## 1806 Scott Street

Planning Rationale Addendum  
Zoning By-law Amendment + Site Plan Control  
September 5, 2023

Prepared for 2851944 Ontario Inc

**LANDSCAPE PLAN**

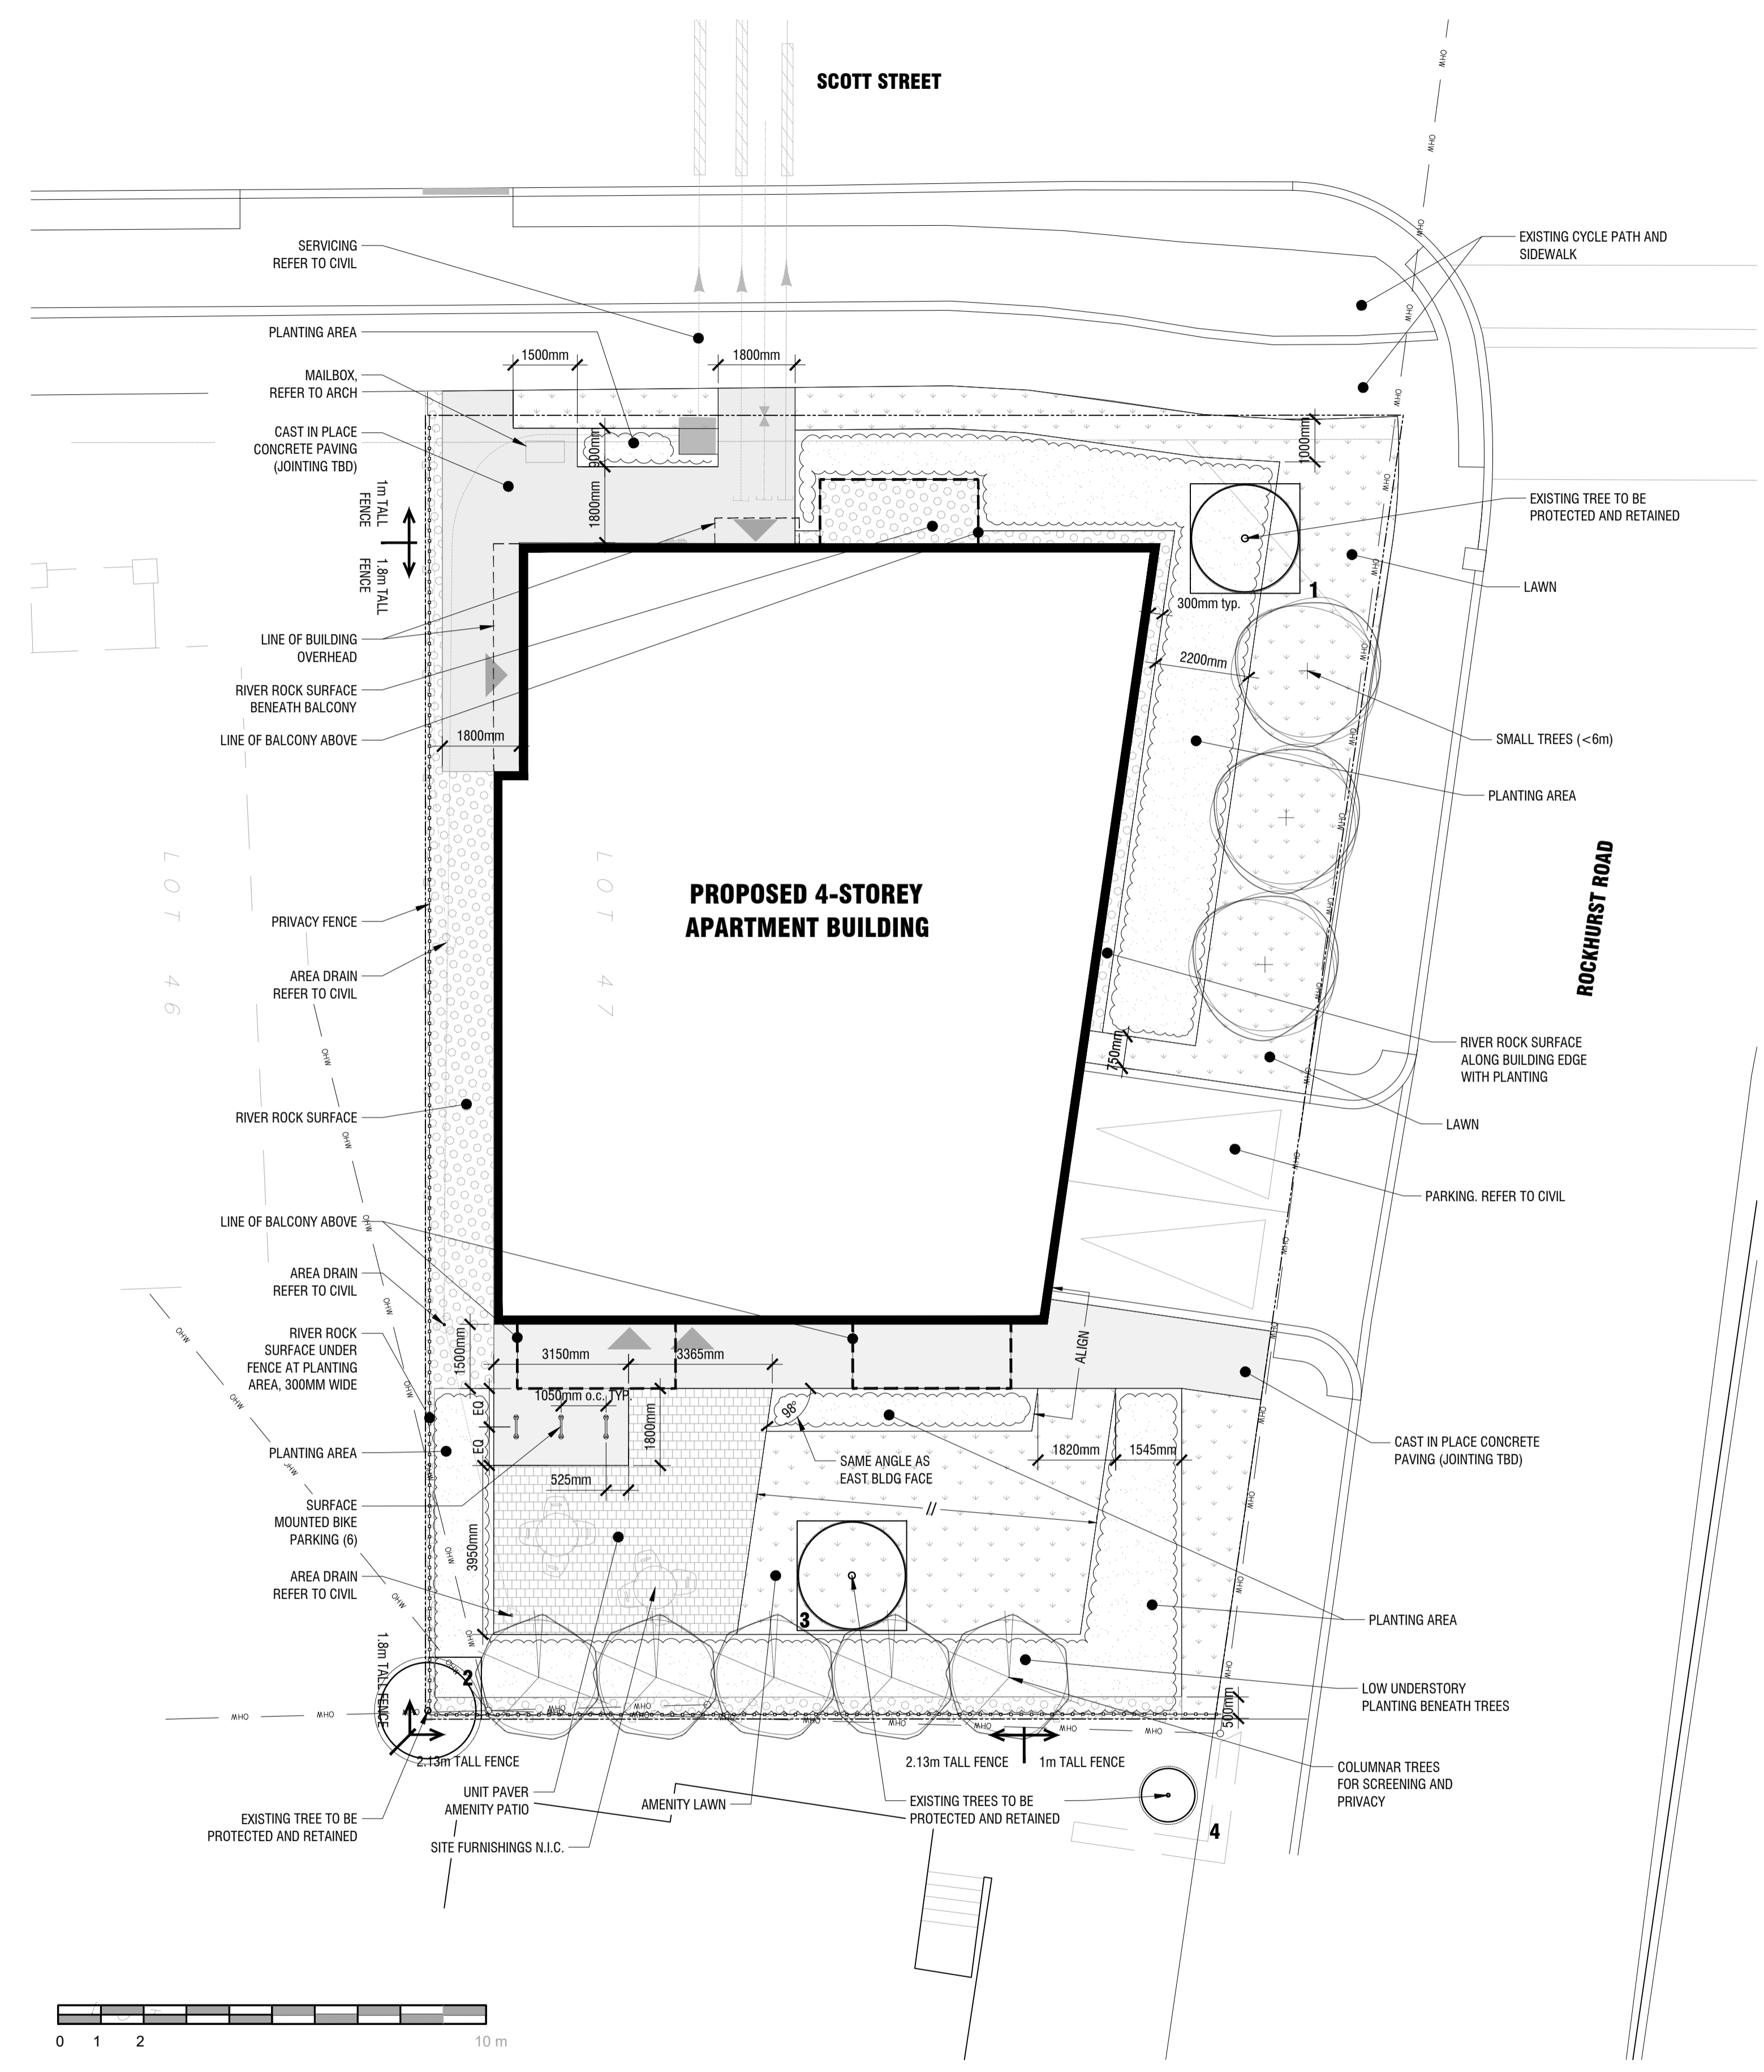
- / Increasing the rear yard setback from 7.5 to 9.23 metres to improve privacy of the adjacent existing residential dwelling to the south and mitigate the potential for overlook;
- / Replacement of the cedar hedge along the south property line with Pyramidal English Oak trees, which will provide increased privacy and screening between the proposed development and the existing residential dwelling to the south;
